REFUSAL OF PLANNING PERMISSION

APPLICATION NO. 2012/1193

**Proposal Erection of front porch and installation of canopy above rear door.
At Woodhead View, Bankend Farm, Bark Lane, Wortley, Sheffield,, S35 7DG**

WOODHEAD VIEW
FRONT ELEVATION - PROPOSED

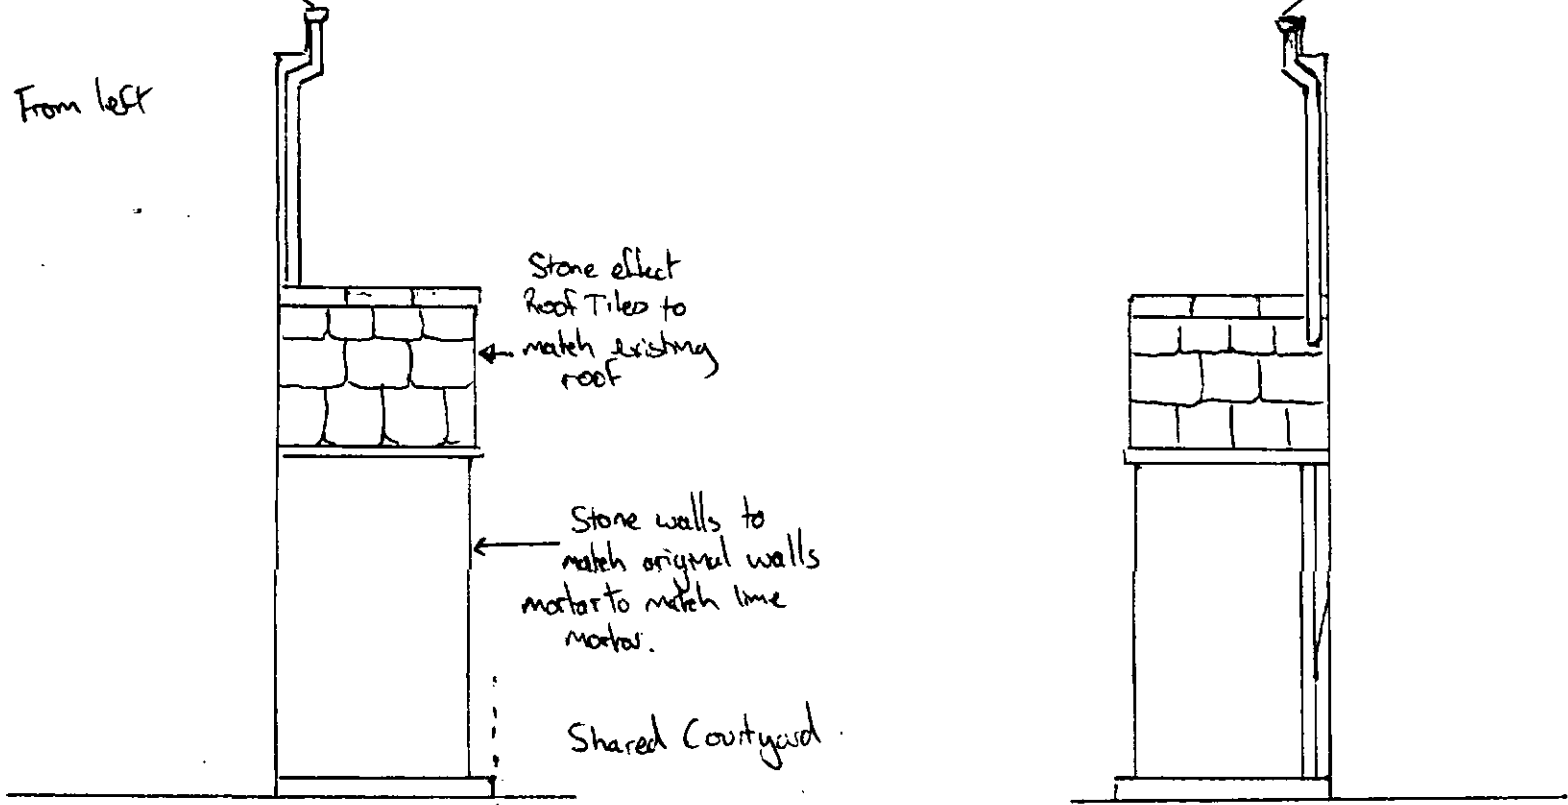
- 1 The proposed porch and canopy, by reason of their modern domestic appearance would be prominent and discordant features detrimental to the special architectural and historic character of the converted barn complex contrary to CSP29 and the SPD Barn Conversions.
